WELWYN HATFIELD COUNCIL – DEVELOPMENT CONTROL
DELEGATED REPORT

APPLICATION No:	S6/2009/1405/FP
------------------------	------------------------

This application seeks full planning permission for a two storey side extension, single storey rear and single storey front extension between the existing lobby area and the neighbours garage. The proposed front and rear extensions are similar to the extant consent with a wider two storey side extension proposed. The proposed two storey side extension would abut the flank site boundary as it narrows towards the rear of the site forming an irregular shape measuring approximately 4.9m in width at the front with a splayed gable wall.

DH. 01

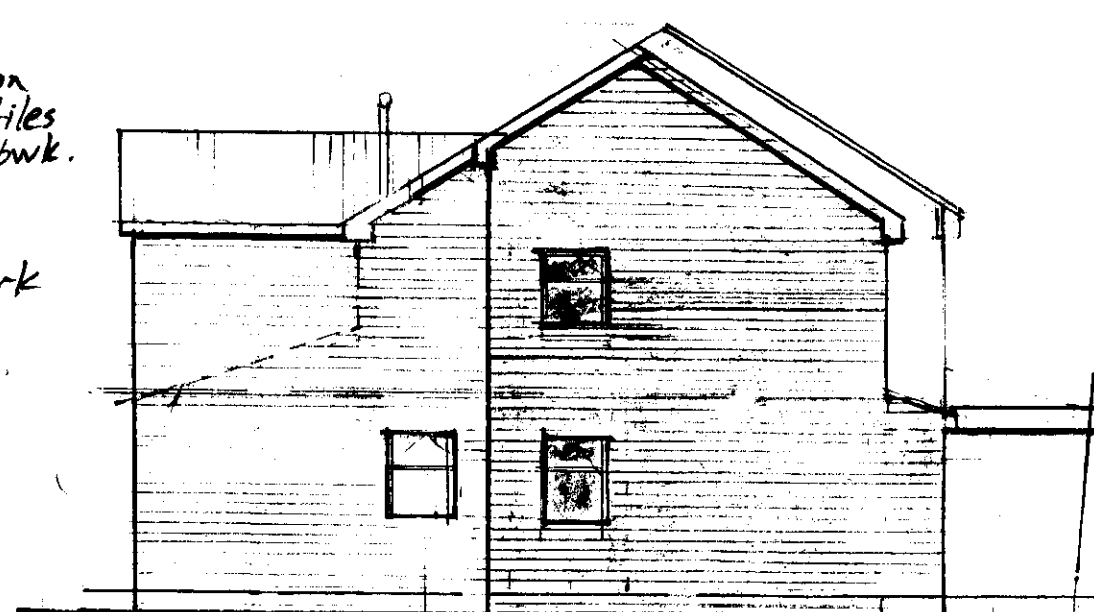
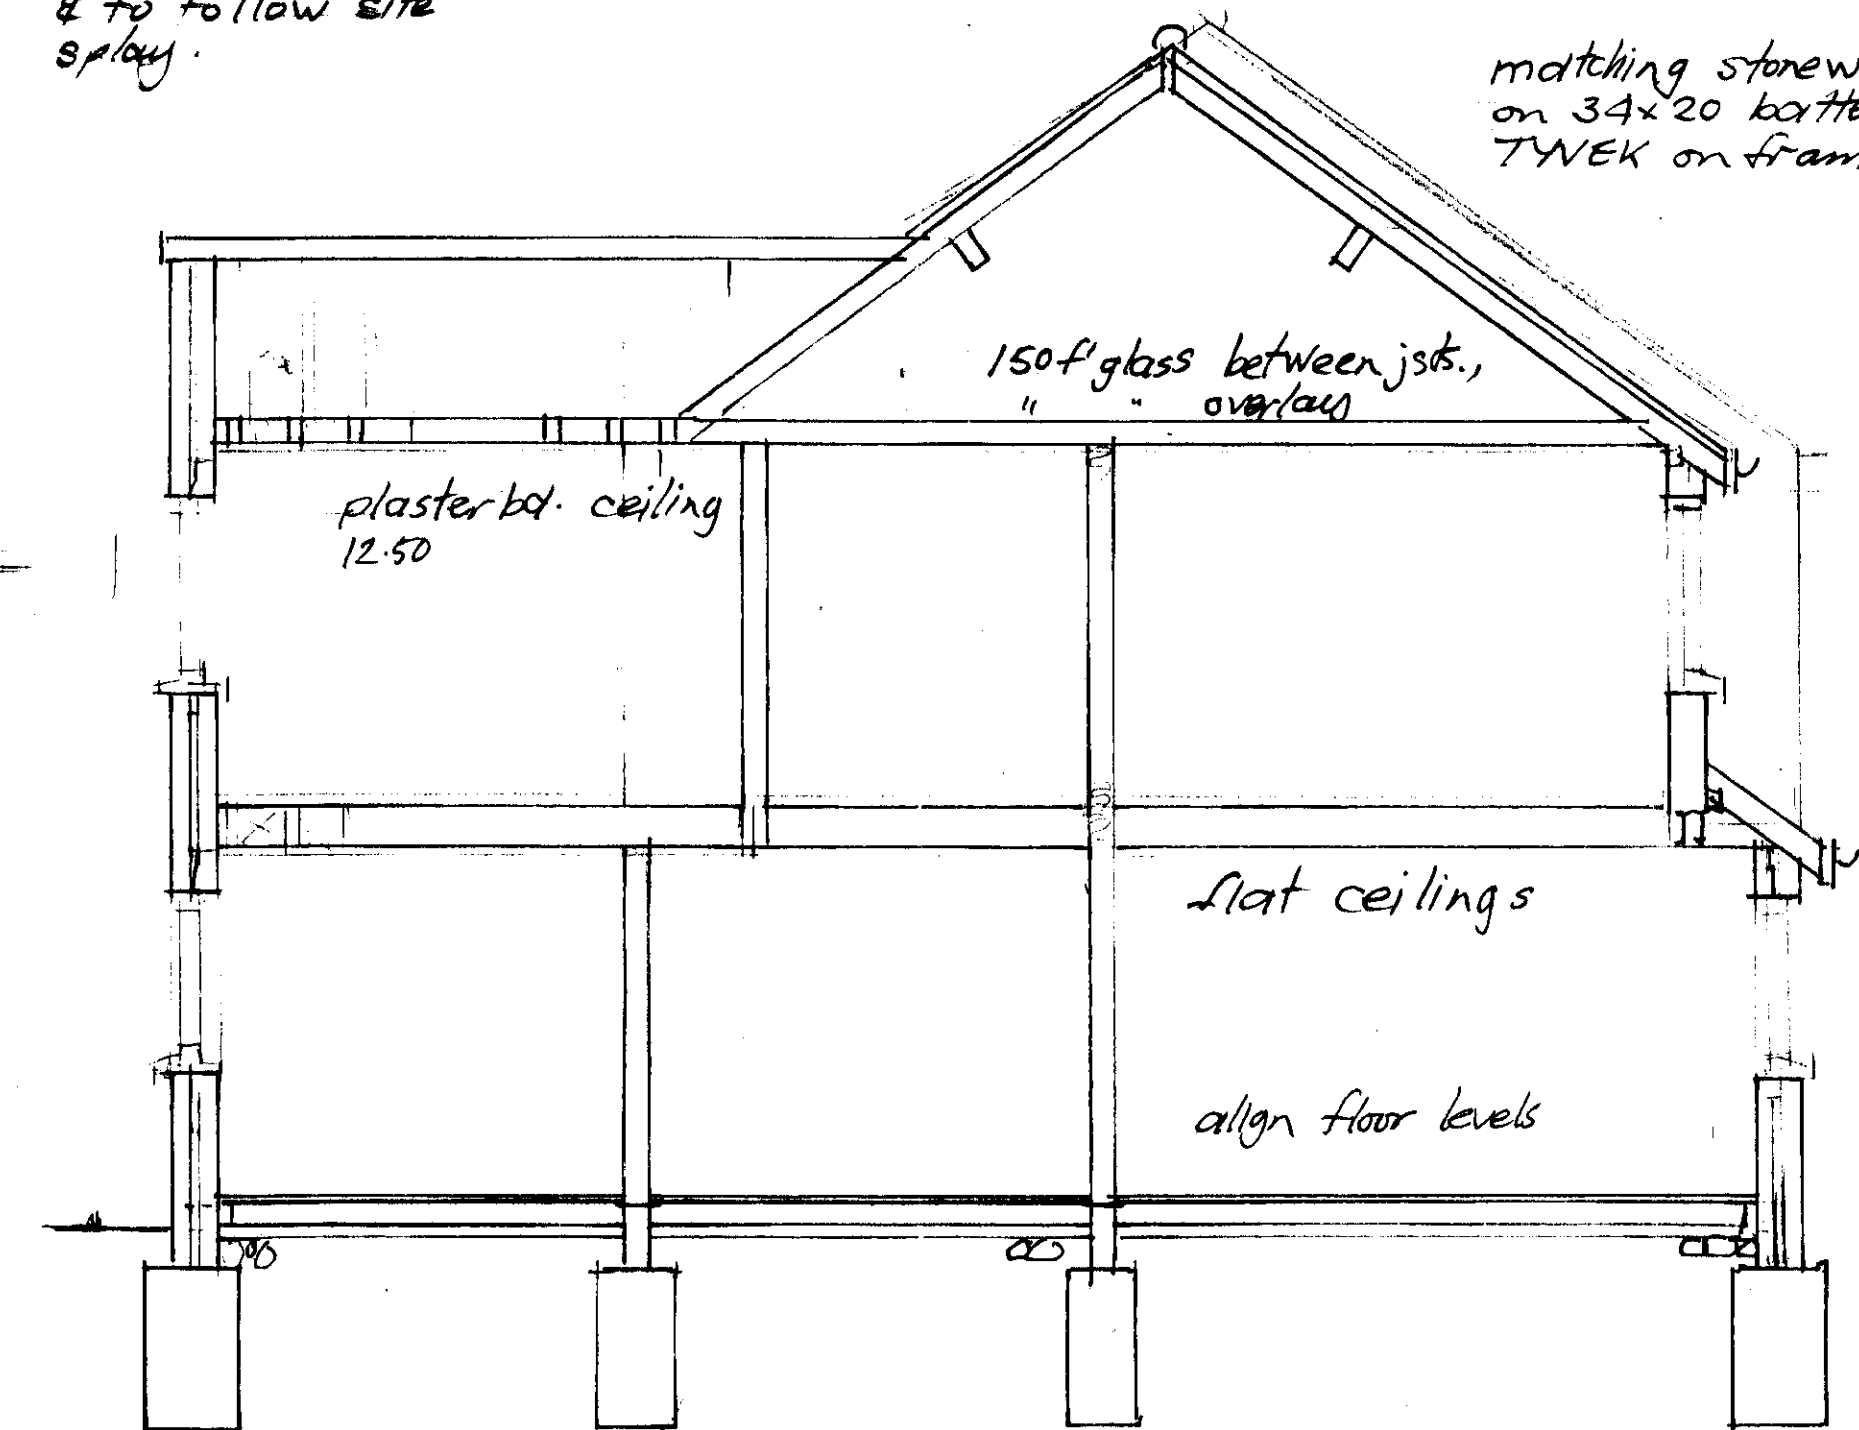
The proposed side extension fails to complement the design and character of the application dwelling and other dwellings within the streetscene. In particular the width of side extension would not be subordinate to the existing dwelling and the splayed flank elevation would have a contrived appearance. The proposed alterations would cause harm character and appearance of the application dwelling and the visual amenity of the street scene. The proposal fails to comply with PPS1, Policy SS1 and ENV7 of the East of England Plan 2008, Policy D1 and D2 of the Welwyn Hatfield District Plan and Supplementary Design Guidance, 2005 (Statement of Council Policy).

Windows are proposed in the flank elevations at both ground (2 windows) and first floor (1 window). The window at first floor would serve a bathroom and is shown to be obscured. The ground floor windows would serve a WC and utility room. The WC is likely to be obscured, however, it would not be unreasonable to include a condition requiring these windows to be obscured glazed and fixed below a height of 1.8m.

1. The proposed two storey side extension would appear unduly prominent and overbearing to the adjacent public footpath failing to maintain or enhance the character of the area. The width of the two storey side extension would not be subordinate in scale to the application dwelling and the splayed flank elevation would have an contrived appearance which fails to complement or reflect the design and character of the existing dwelling. The proposed extensions are therefore contrary to PPS1, Policy ENV7 of the East of England Plan 2008, Policy D1 and D2 of the Welwyn Hatfield District Plan and Supplementary Design Guidance, February 2005 (Statement of Council Policy)

Ground floor

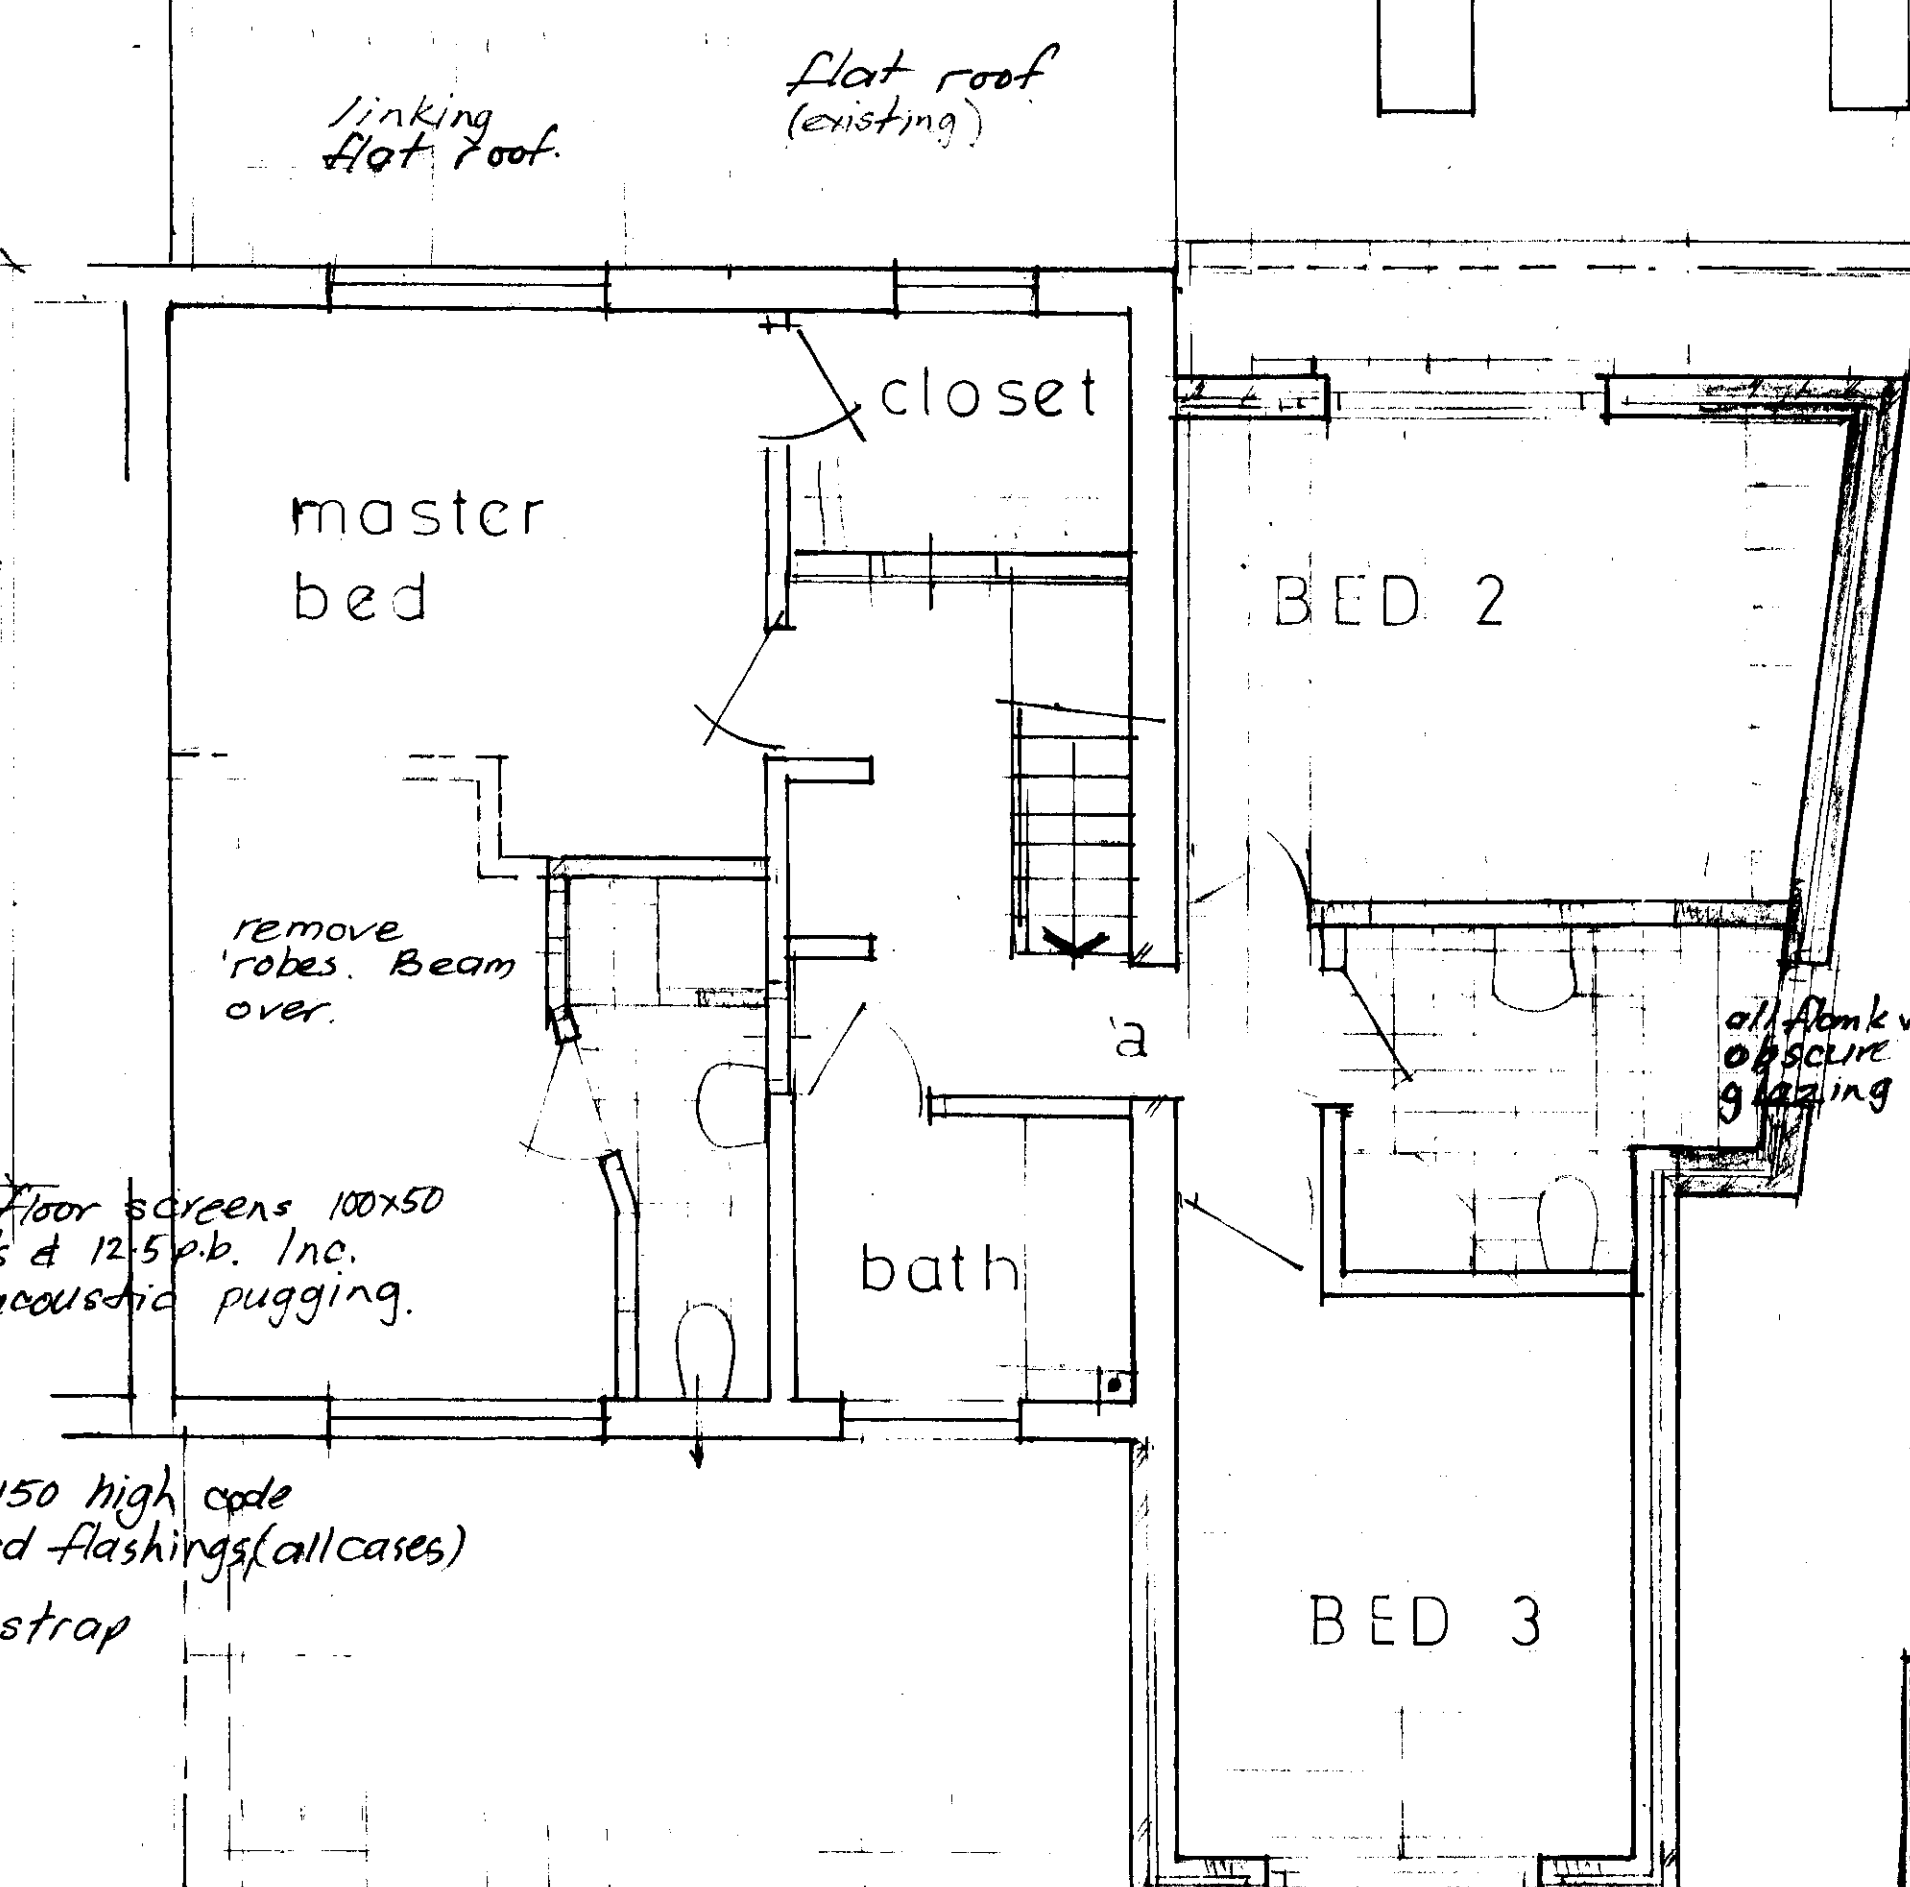
The proposal would include a single storey front extension set adjacent to the neighbours garage. It would not project forwards of the garage and therefore would not have impact.

The single storey rear extension would be set adjacent to the neighbours boundary. The neighbour has not extended their dwelling to the rear of their dwelling. The extension would project 3m beyond the existing rear elevation. The extension would have some impact upon the adjoining neighbour, however it is considered that its impact would be fairly limited, and bearing in mind that this depth of extension could be built under permitted development, it is not considered that it should be refused.
